From: Laura Gibbons [REDACTED]
Sent: 16 June 2020 12:12
To: Planning.Responses <Planning.Responses@arun.gov.uk>
Cc: Michael Eastham <Michael.Eastham@arun.gov.uk>
Subject: Fwd: FW: Angels Nursery - Planning Consultation on BN/30/20/DOC

Please see our further comments regarding surface water drainage relating to BN/28/20/DOC. 16/06/20 review comments are shown in *red italics*, items that are now closed are striked through.

Site Address: Land At Angels Nursery Yapton Road Barnham PO22 0AY

PRECAST CONCRETE CONTROL CHAMBER

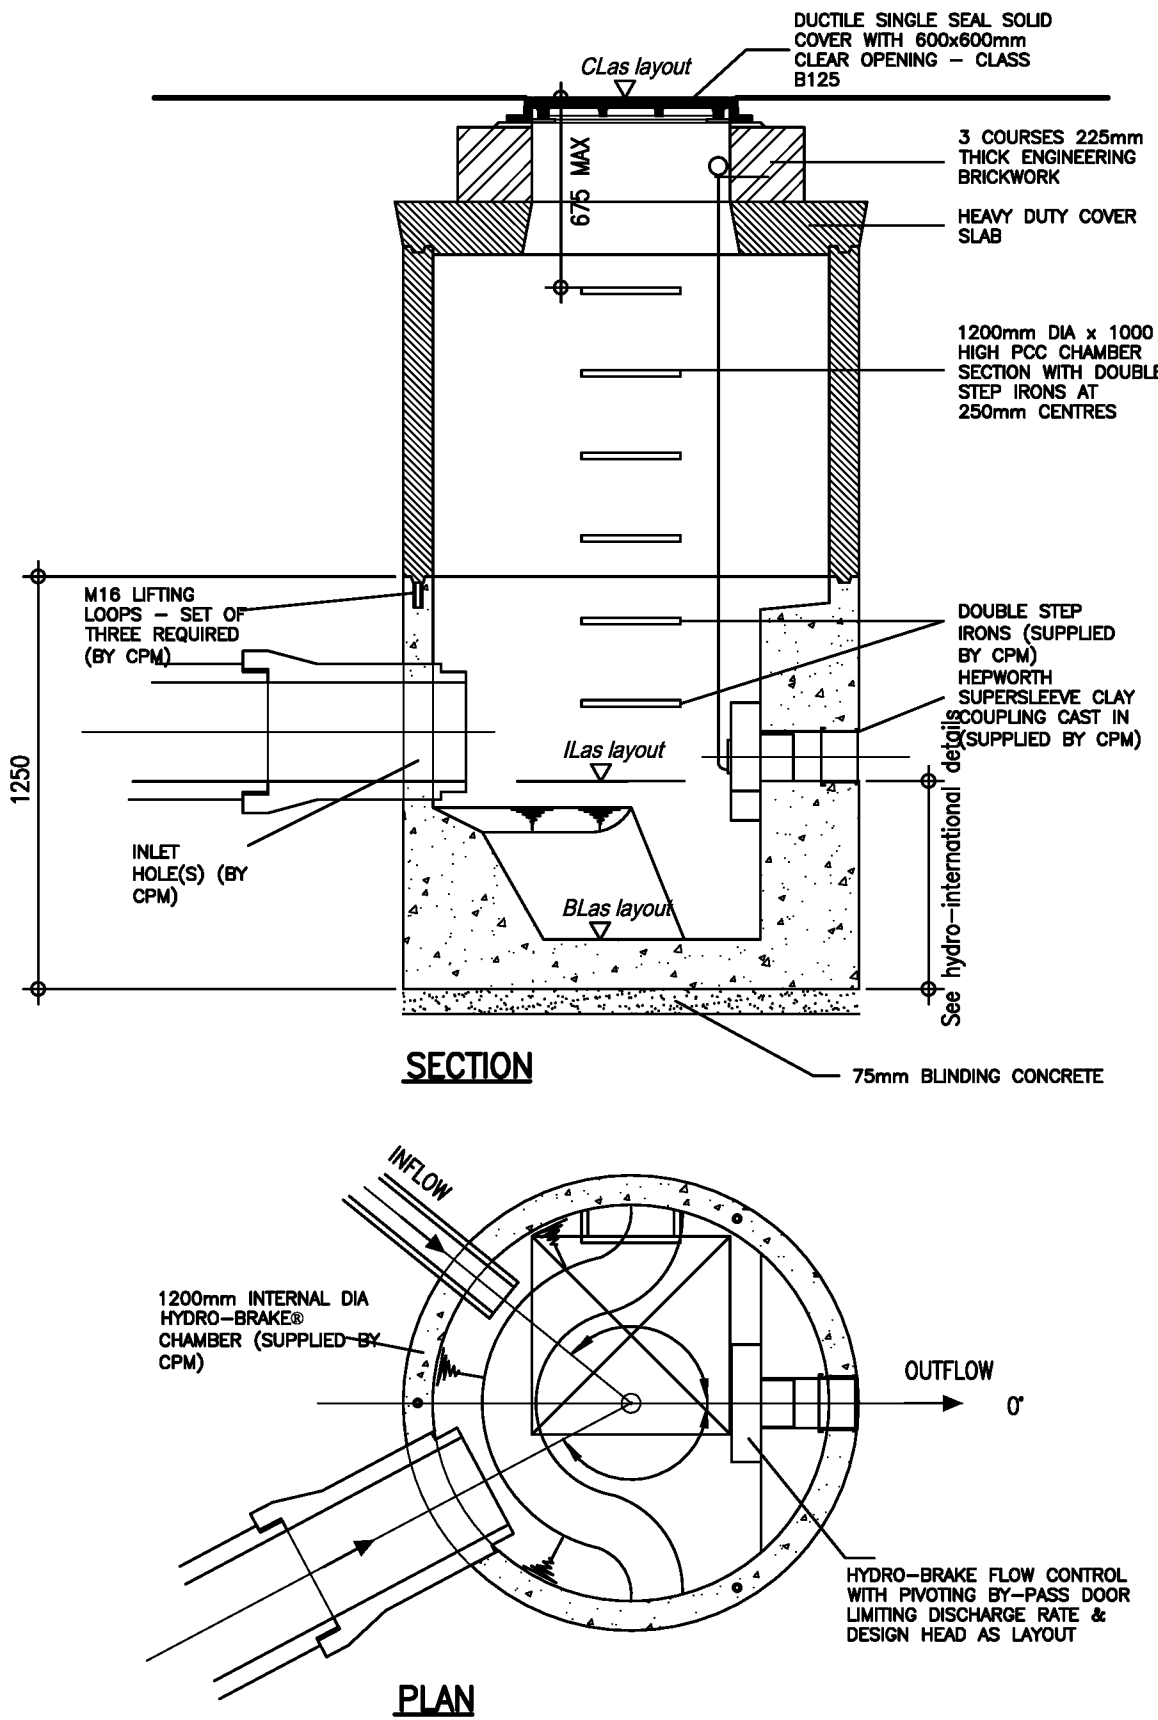
64. Hydrobrake chamber detail – rings to be surrounded in 150mm thick concrete and to be extended down to the bottom of its base. All to be ST4 concrete. Add benching construction notes and include hydro international details referred to.

64. Hydrobrake chamber detail – rings to be surrounded in 150mm thick concrete and to be extended down to the bottom of its base. All to be ST4 concrete. Add benching construction notes and include hydro international details referred to. *Note is not clear that surround extends to bottom of base, benching note missing, hydro international details not included.*

TYPICAL PRECAST CONCRETE
CATCHPIIT

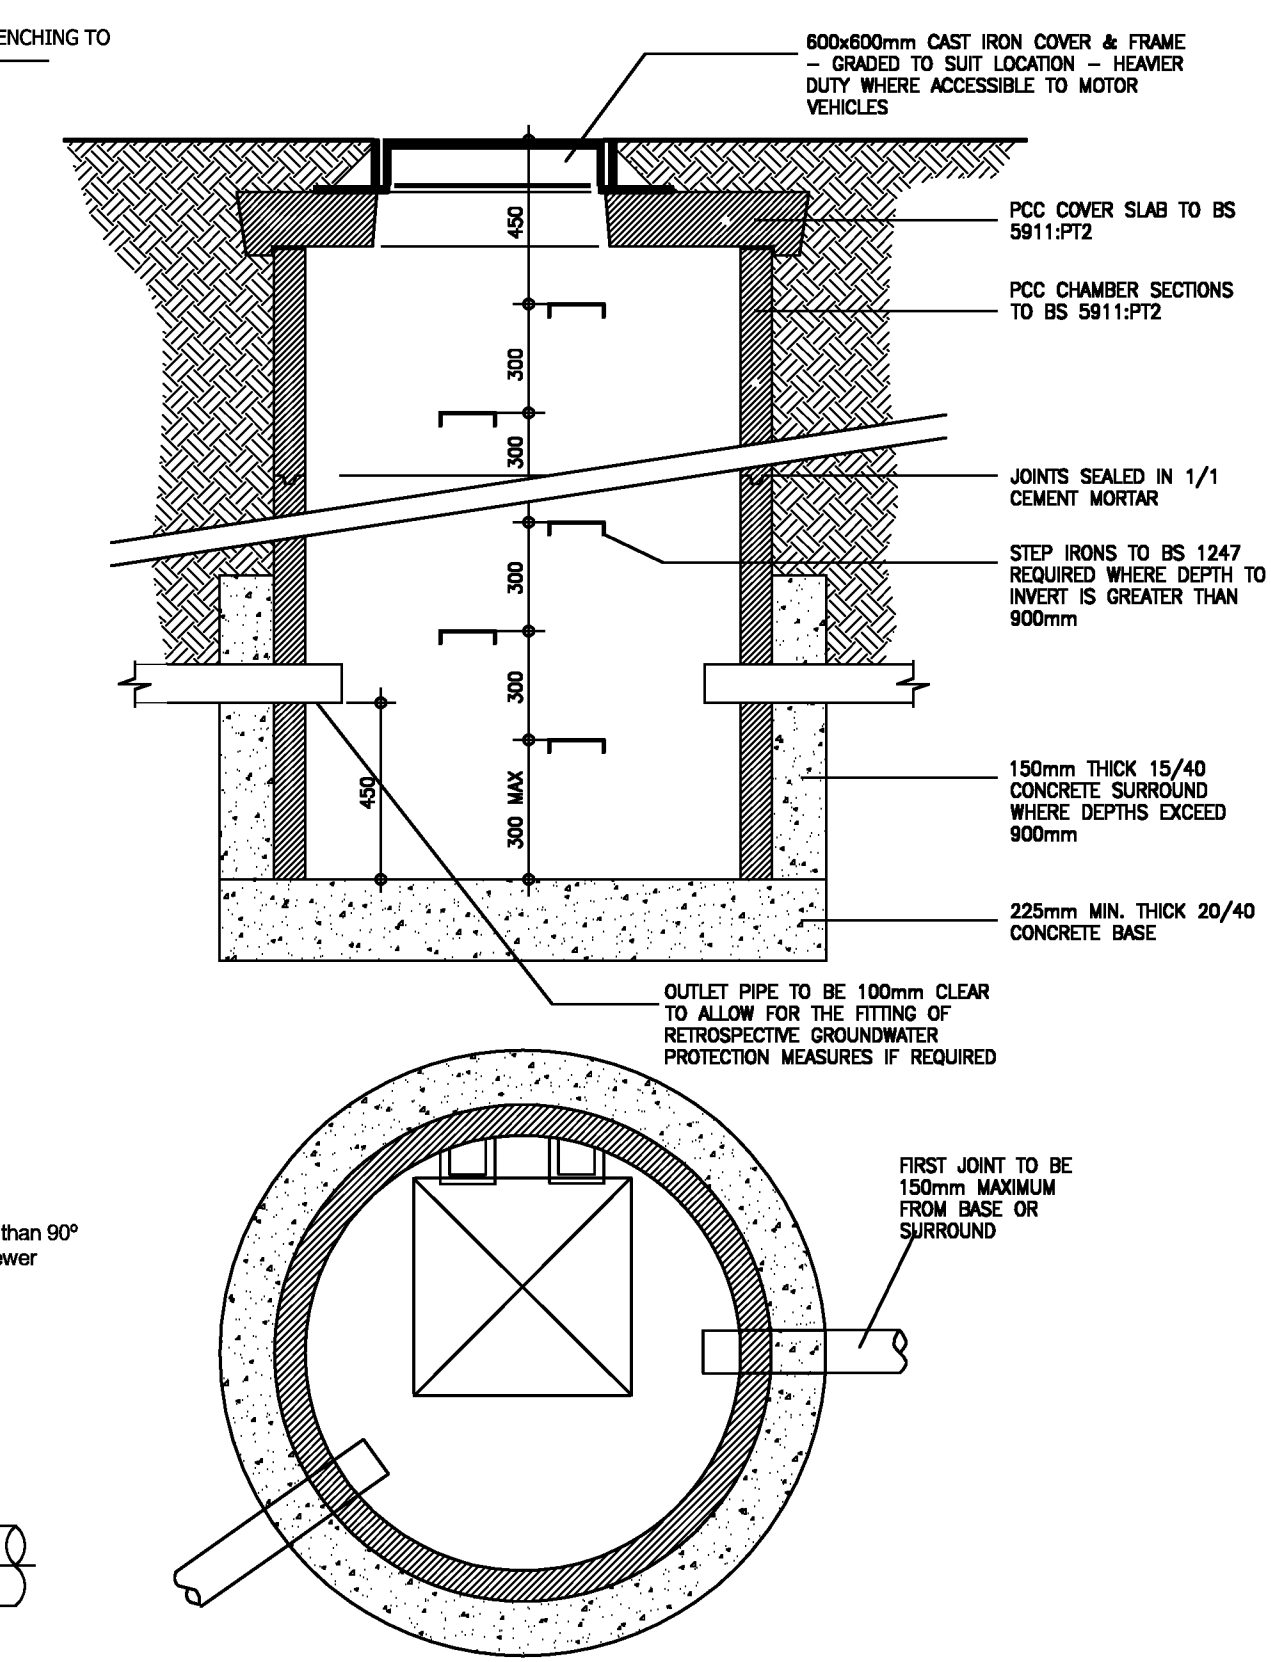
65. PCC ring catchpit detail – unsure if this type is being specified anywhere? If, so detail where and include brickwork under manhole cover/frame and extend concrete surround up to top of cover slab. Specify ring diameter.

65. PCC ring catchpit detail – unsure if this type is being specified anywhere? If, so detail where and include brickwork under manhole cover/frame and extend concrete surround up to top of cover slab. Specify ring diameter. *Unclear as to where specified, include MH schedule.*

ADOPTED OUTFALL HEADWALL
SCALE 1:25

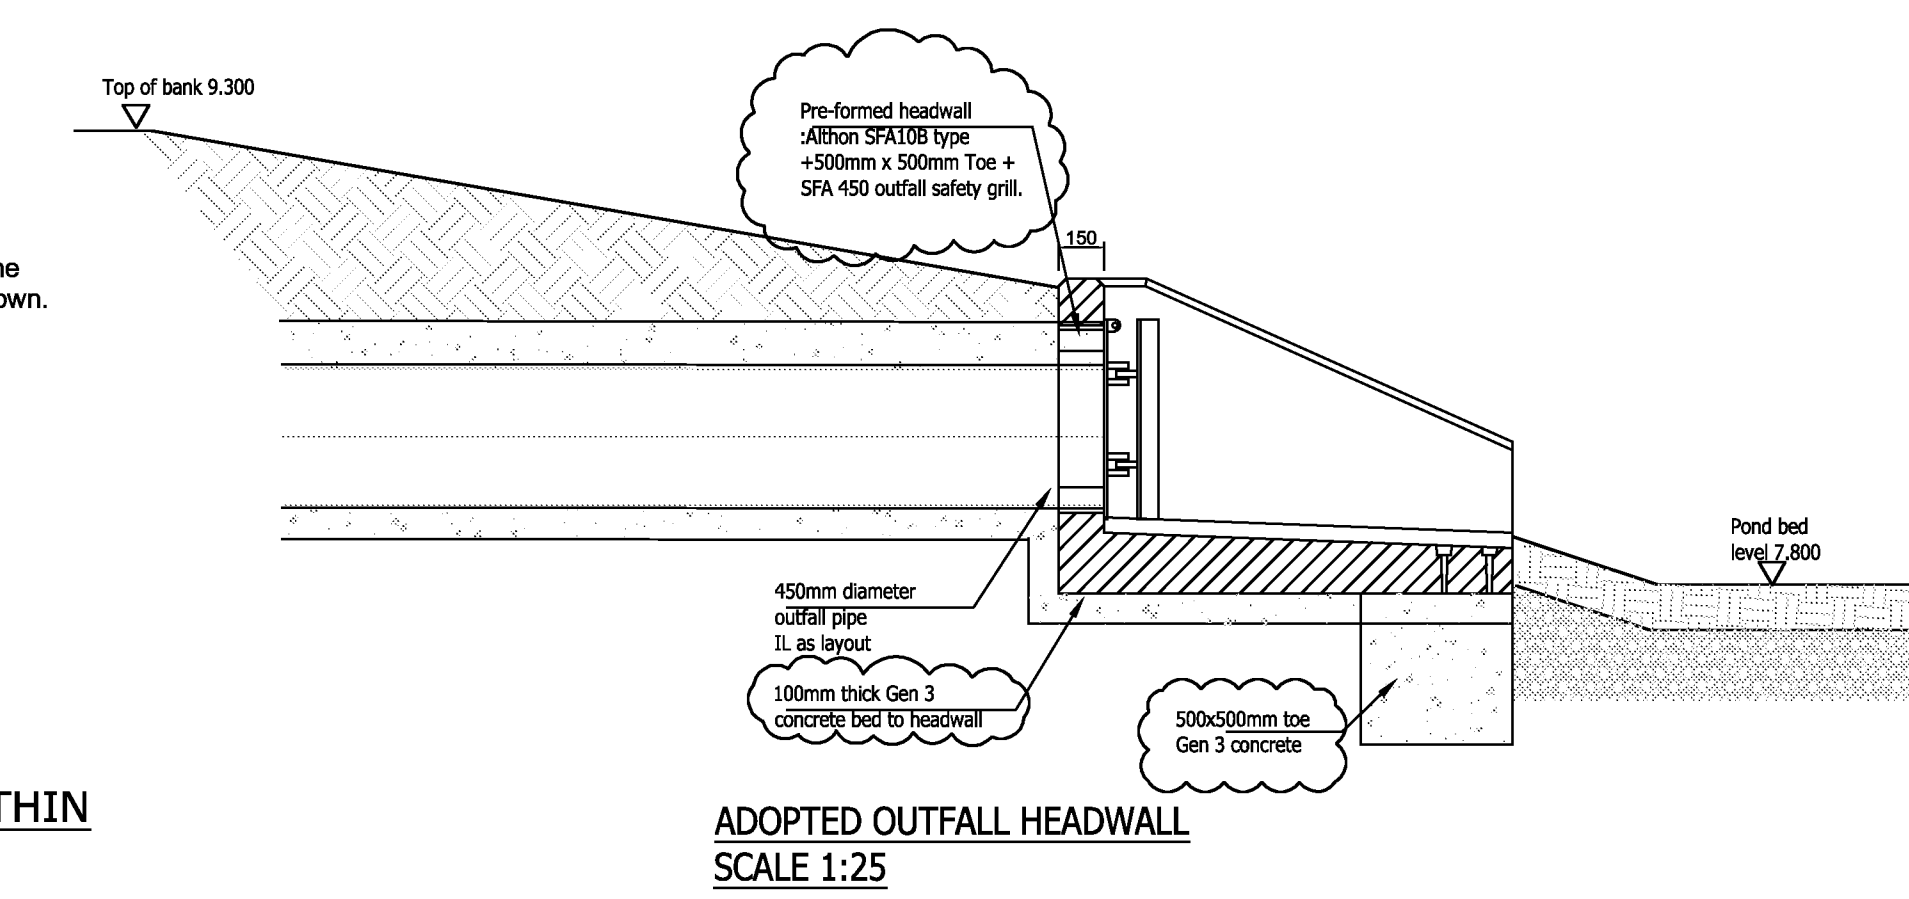
66. Provide catch pit detail for all manholes immediately upstream of permeable paving connections.
 67. Adoptable outfall headwall detail – remove flat grille and specify cranked including bar spacings, etc. Incorporate Athlon detailed drawing within this drawing. Pond bed level shown as 7.800 but 7.900 on plans.

66. ~~Provide catch pit detail for all manholes immediately upstream of permeable paving connections.~~ *Okay.*
67. Adoptable outfall headwall detail – remove flat grille and specify cranked including bar spacings, etc. Incorporate Athlon detailed drawing within this drawing. Pond bed level shown as 7.800 but 7.900 on plans. *Please address points.*

**DISTRIBUTION/COLLECTOR TANK DETAIL WITHIN
TANKED PERMEABLE PAVING (MARKED DT ON LAYOUT)**

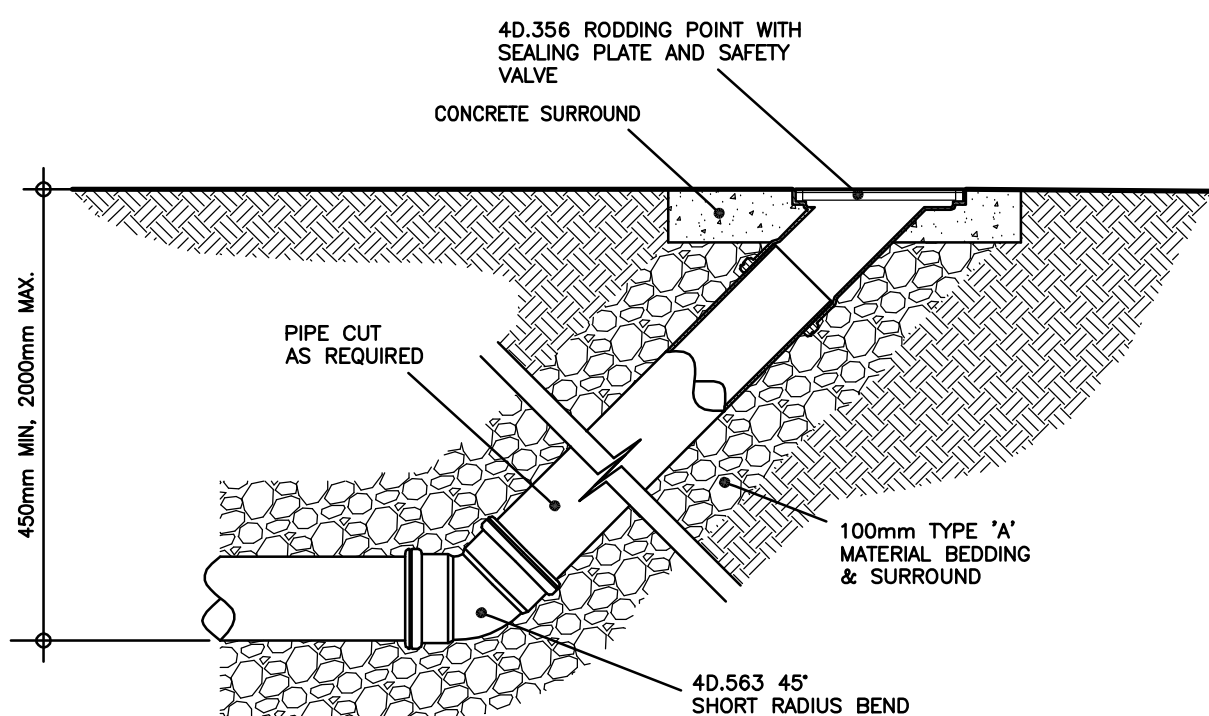
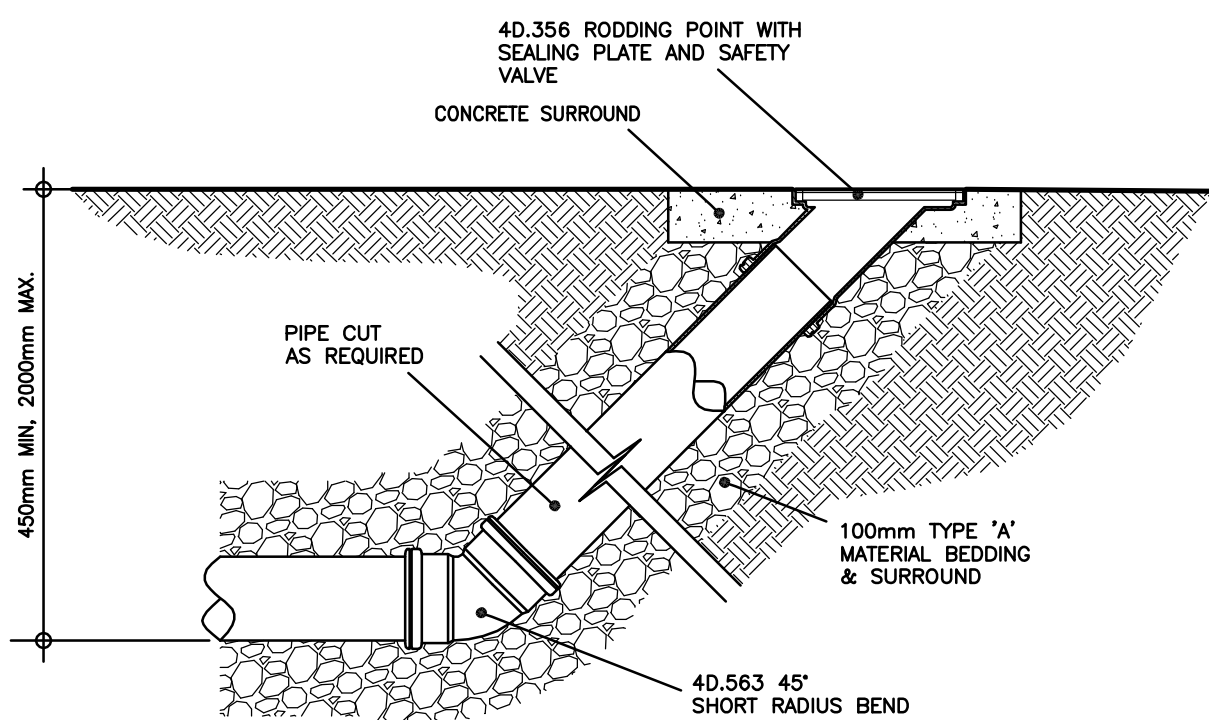
72. Provide pond construction detail including impermeable liner and any necessary anti-buoyancy measures. Floatation calcs to be provided.
 73. Provide construction detail distribution tanks on permeable paving outlets.

73. Provide construction detail distribution tanks on permeable paving outlets. *Please make it clear that invert level of outlet tanks is at formation level.*

CONCRETE BAFFLE DETAIL

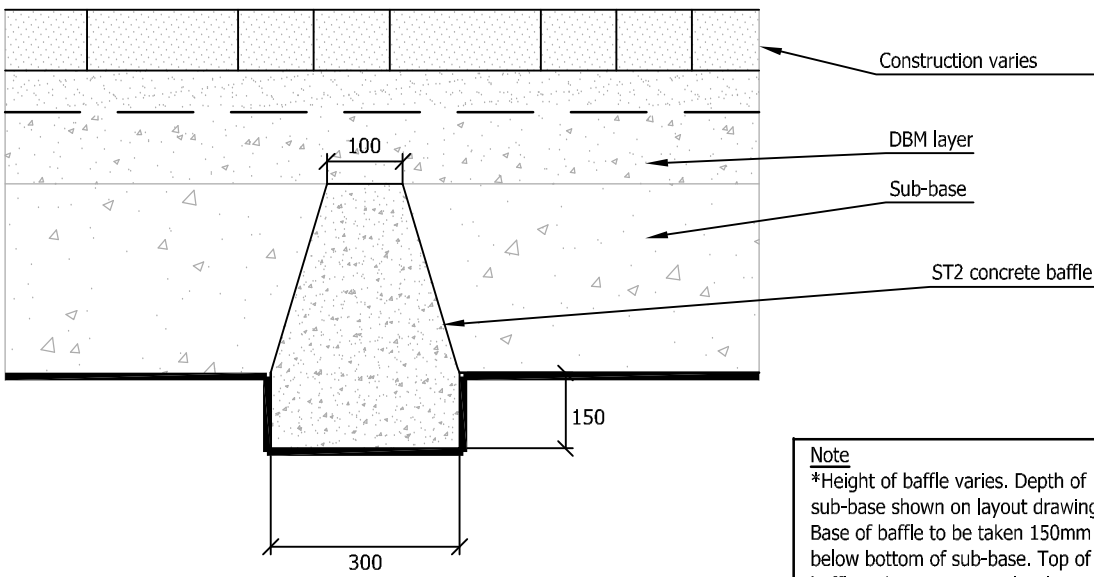
70. Provide sloping formation permeable paving detail.
 71. Baffle detail – Make it clear that the top of the concrete is level with the top of the sub base.

70. Provide sloping formation permeable paving detail. *Please provide.*
71. ~~Baffle detail – Make it clear that the top of the concrete is level with the top of the sub base.~~ *Okay.*
